Our Ref: R/177/18/PDH
Your Ref:

Town and Country Planning Act 1990 (As amended)
Town and Country Planning (General Permitted development) Order 2015 Schedule 2 Part 1
Class A
Application for Prior Notification for a householder extension

Development Notification under extended permitted development rights for a new proposed single storey rear extension extending 4m from the original rear wall of the dwelling house, 2.5m metres high with an eaves height of 2.5m

Location 12 Southcourt Close Rustington

Proposed Floor Plan, Proposed Elevations, Roof Plan and Block Plan

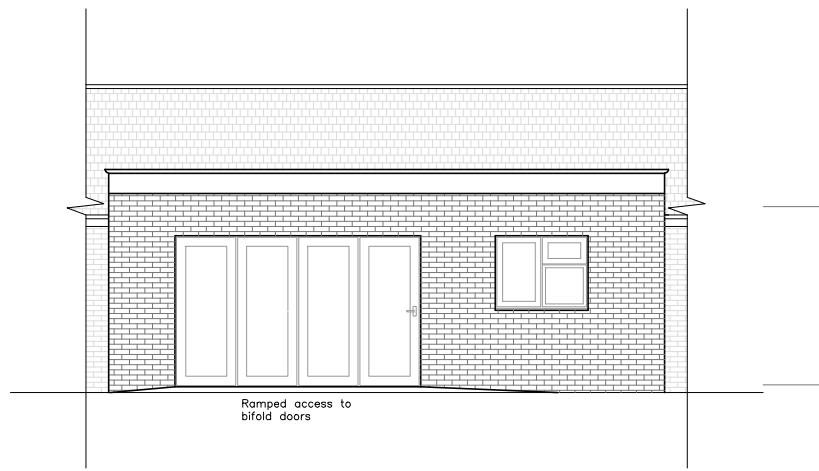
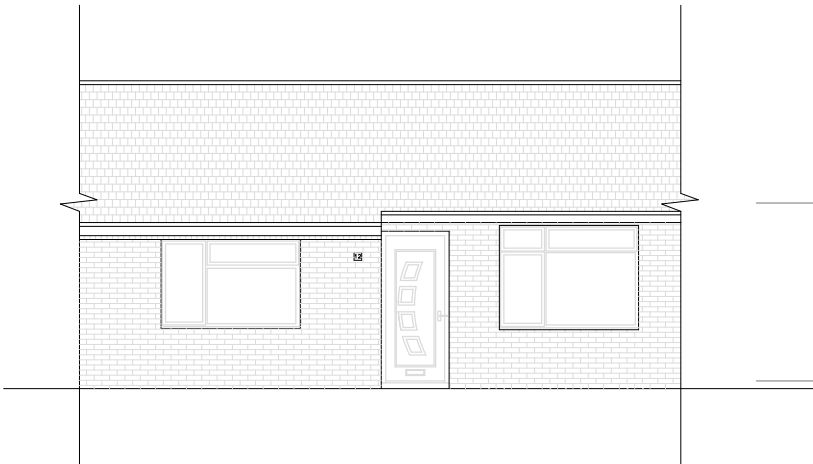
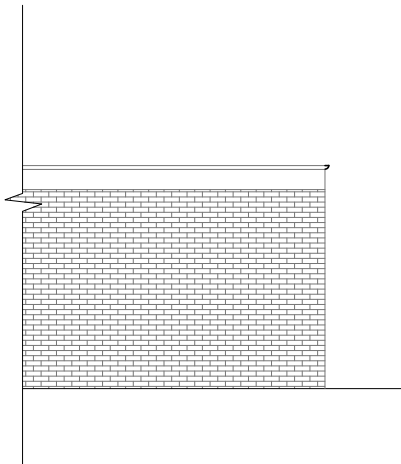
Also please note the eaves height and the total height of the proposed extension should differ very slightly. Please could you amend the application as such.
